INFRASTRUCTURE PLANNING (EXAMINATIONS PROCEDURE) RULES 2010, RULE 17**PROPOSED FIVE ESTUARIES OFFSHORE WIND FARM DEVELOPMENT CONSENT ORDER****PINS REFERENCE EN010115****LONDON GATEWAY PORT LIMITED****RESPONSE TO THE EXAMINING AUTHORITY'S REQUEST FOR FURTHER INFORMATION OF 27 JANUARY 2025**

Addleshaw Goddard LLP
11 February 2025

APPENDIX 1 - PROPOSED AMENDMENTS TO ORDER [REP5-007] BY LONDON GATEWAY PORT LIMITED IN RESPONSE TO EXA RULE 17 REQUEST OF 27 JANUARY 2025

APFP Regulation: 5(2)(a)  
 Sheet No: 6 of 7

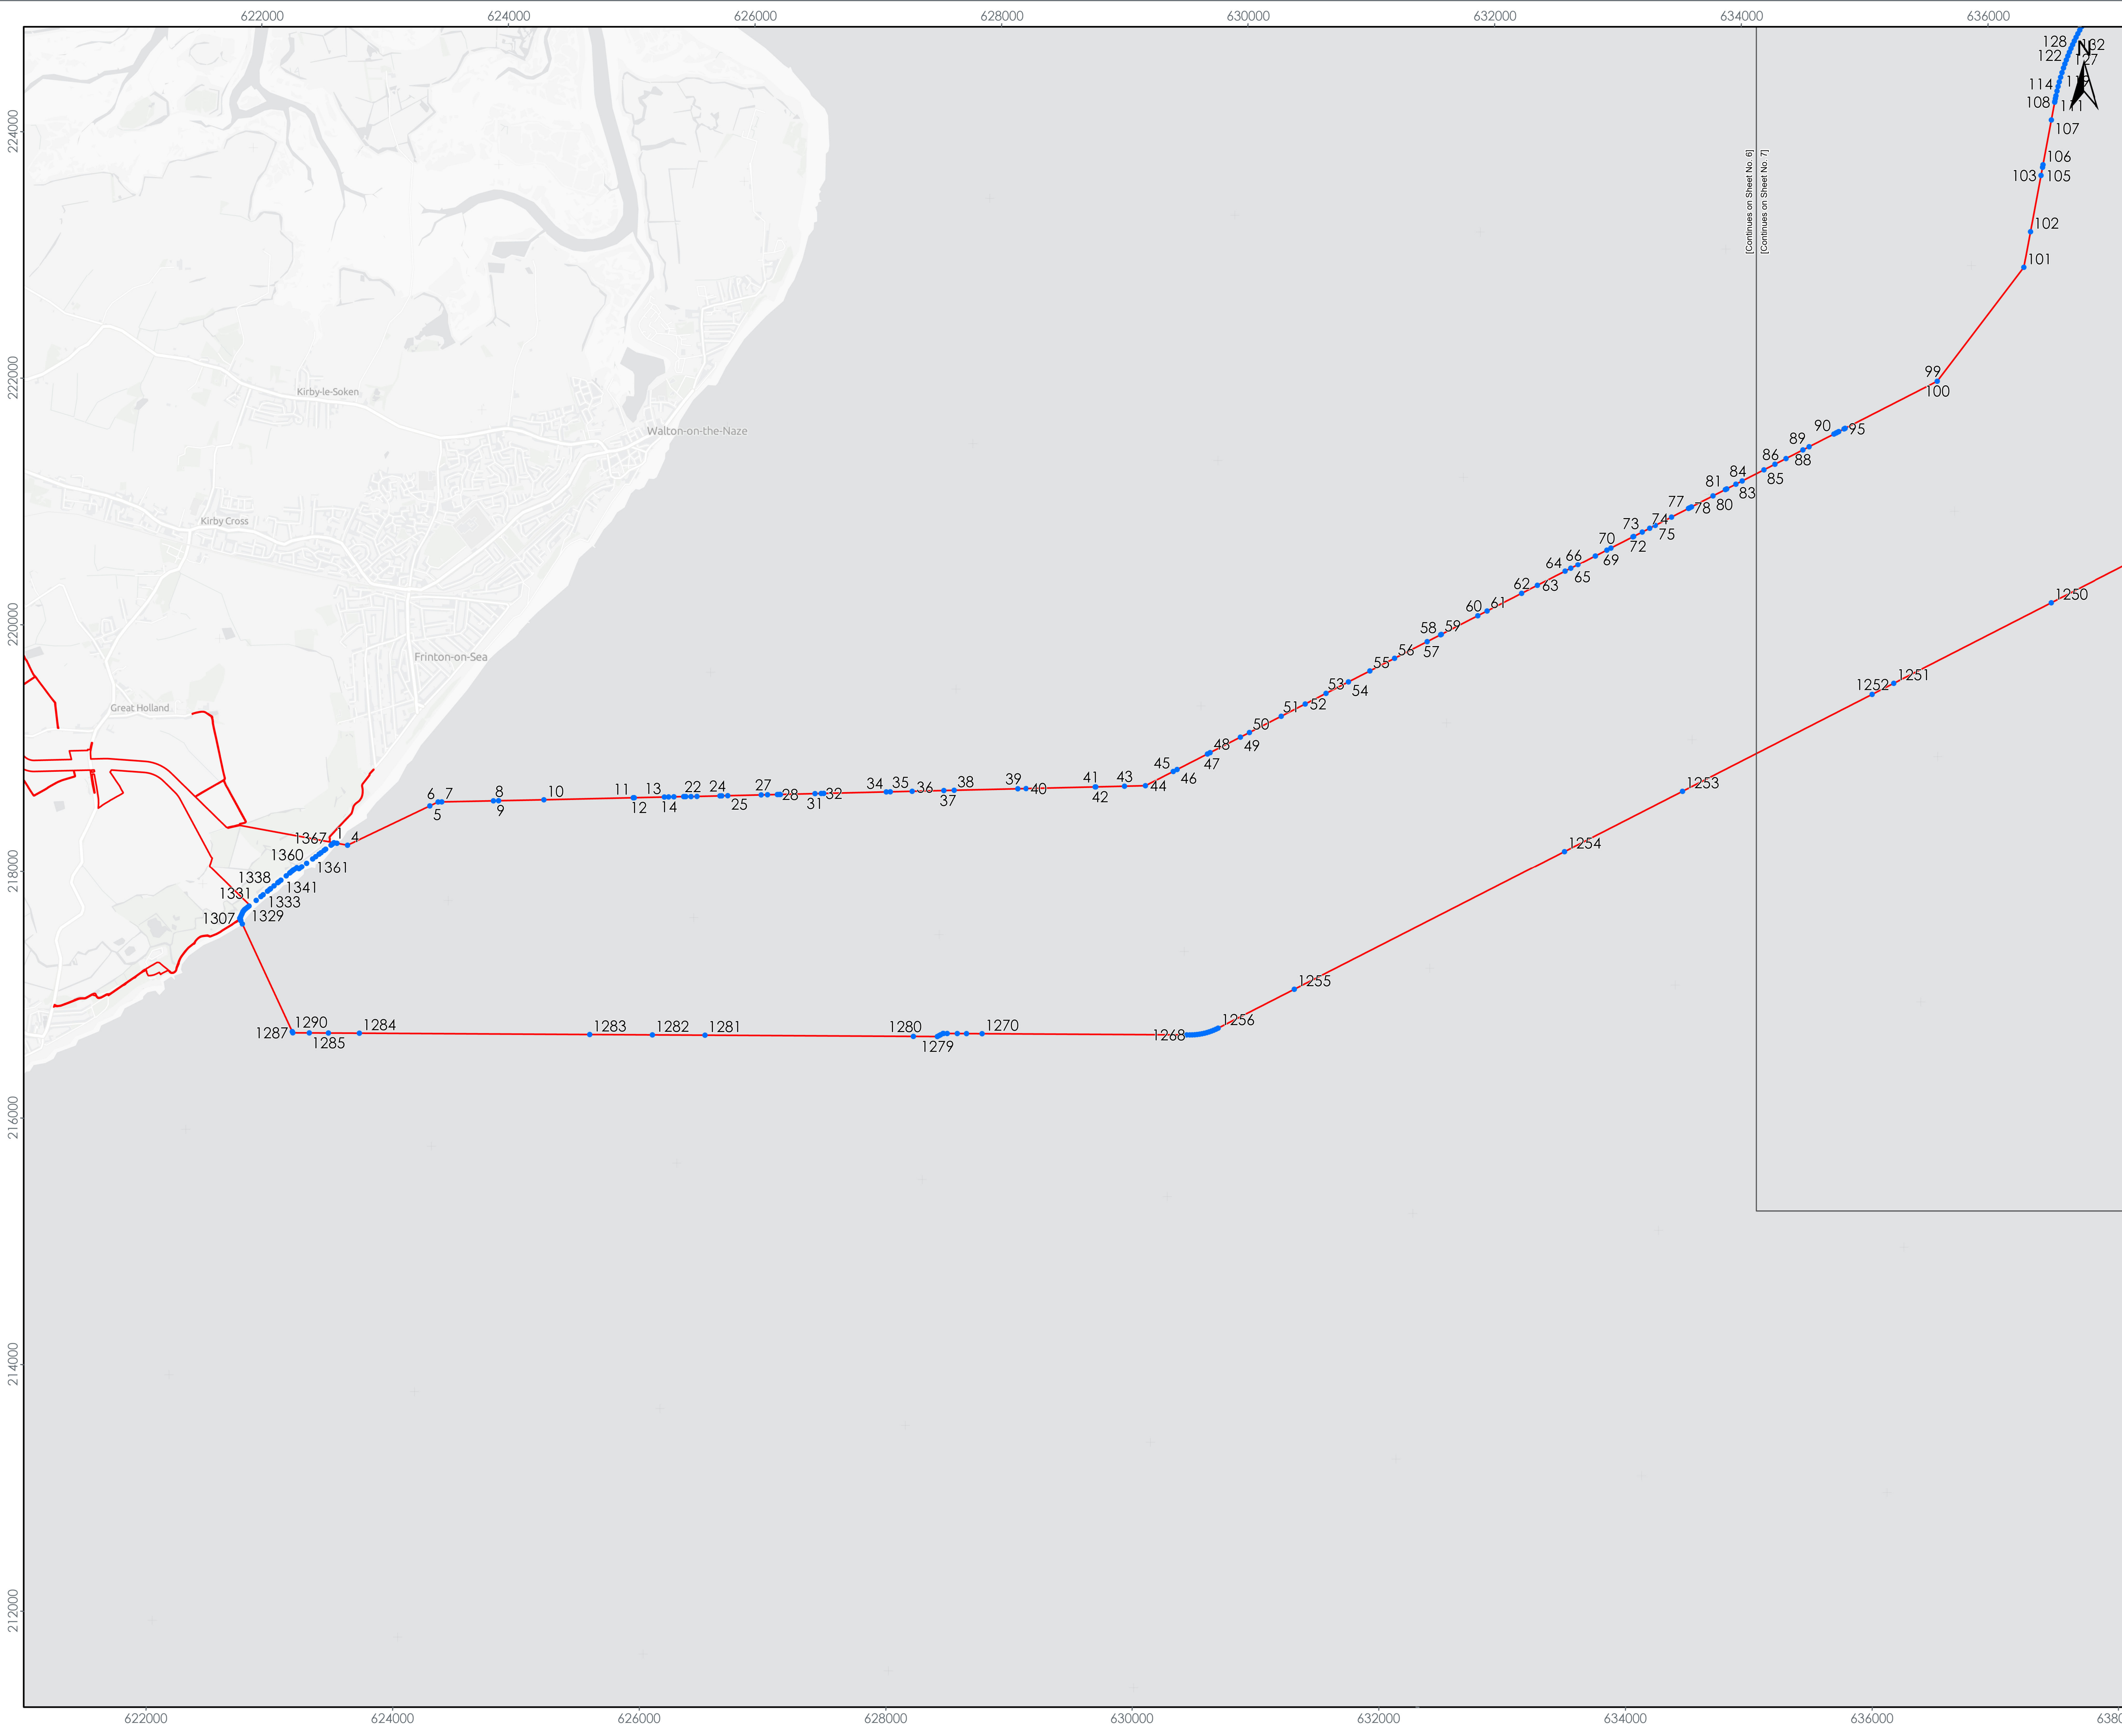
- 4.4 Accordingly, we would propose a new Requirement to be inserted in Schedule 2 for clarity. We set out the necessary drafting in **Appendix 1** to this response. This would be accompanied by a slight addition to sheet 6 of the works plan (offshore) to show the relevant areas. For reference purposes, they are currently shown on the plan attached as **Appendix 2**.

3 Modify sheet 6 of the works plan (offshore) to show the relevant areas referred to above, as per the attached plan. *[We would suggest adding the information to the existing works plan (offshore) is a better approach than adding a further new plan to the certified documents – it should present a more simplified situation for any subsequent contractors.]*

""Deep Water Routes" means those parts of the Order limits within the Sunk and Trinity channels that are respectively more particularly shown [edged in black and shaded yellow] and edged in [dotted blue and shaded yellow] on sheet [6] of the works plan (offshore);"

""Deep Water Routes Buffer" means those parts of the Order limits within an area 200m either side of the Sunk channel that are more particularly shown [cross hatched in orange and shaded in yellow] on sheet [6] of the works plan (offshore);"

3A-(1) The undertaker must ensure that in the design, implementation, operation and maintenance of the authorised development and ancillary works, a dredged depth of the Deep Water Routes to a depth of 22m below CD is not precluded or impeded.

(2) The undertaker must ensure that in the design, implementation, operation and maintenance of the authorised development and ancillary works, a dredged depth of the Deep Water Routes Buffer to a depth of 19m below CD is not precluded or impeded.
